Application for approval of matters reserved by condition imposed under AW/211/14/PL relating to conditions 3, 6, 11 & 12 relating to window detailing, watercourse access & maintenance, Servicing Management Plan & pedestrian improvements.

The Ship Inn Aldwick Street Aldwick

Thank you for your internet representation made on 16th April 2015 which has been recorded as **'an objection'** with the comments as follows:

FRONT ELEVATION

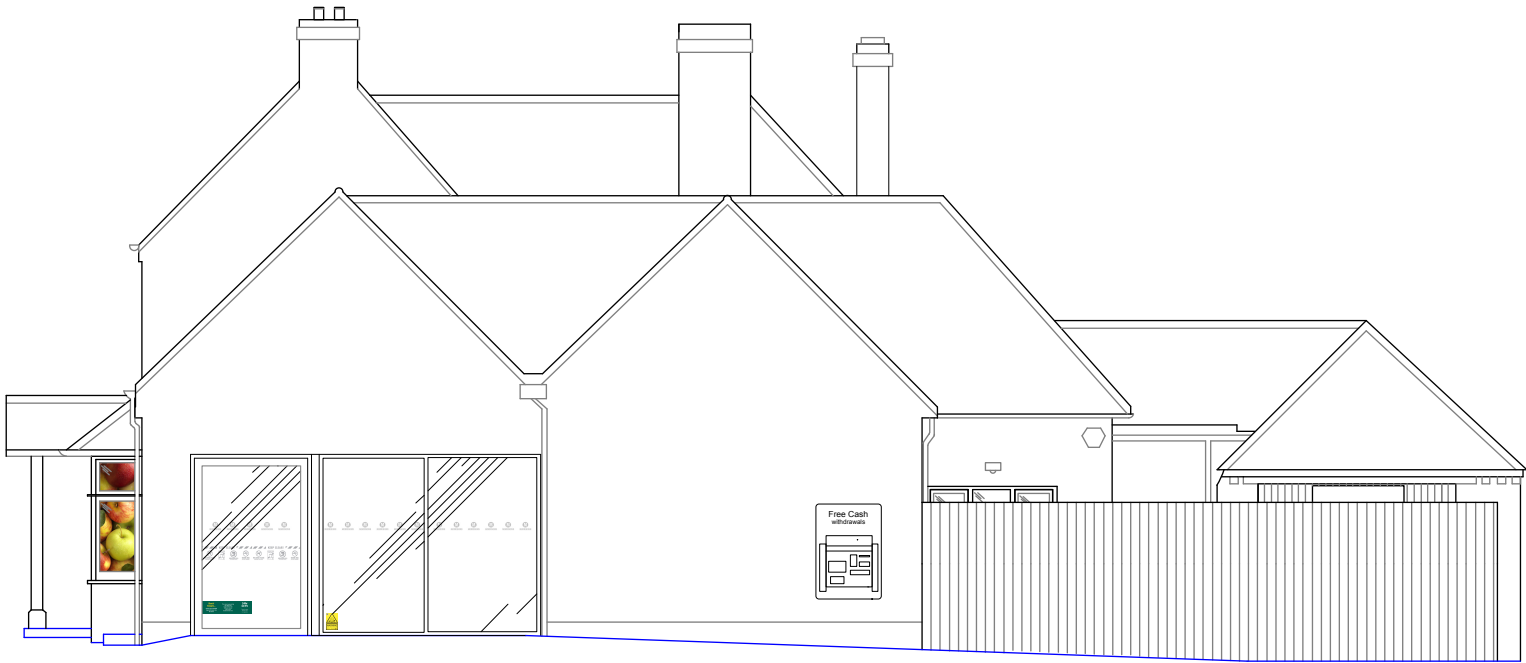
This is an area of special character and pictures of fruit in the windows does not comply with this. Originally in order to win public support Mottrisons stated that they would retain the character of the Ship inn by leaving the wording on the South elevation (now removed) and by filling the windows with pictures of Old Aldwick. Their excuse that the photographs are not of sufficient good quality to be enlarged is just not sustainable. It may cost a bit extra to have them enhanced but they shouldn't have stated that they would do this originally if they had no intention of completing it.
Also a traffic calming / pedestrian crossing is imperative before someone is injured or killed crossing the road. This was insisted upon by the Planning and Development Committee members before giving planning permission back in December
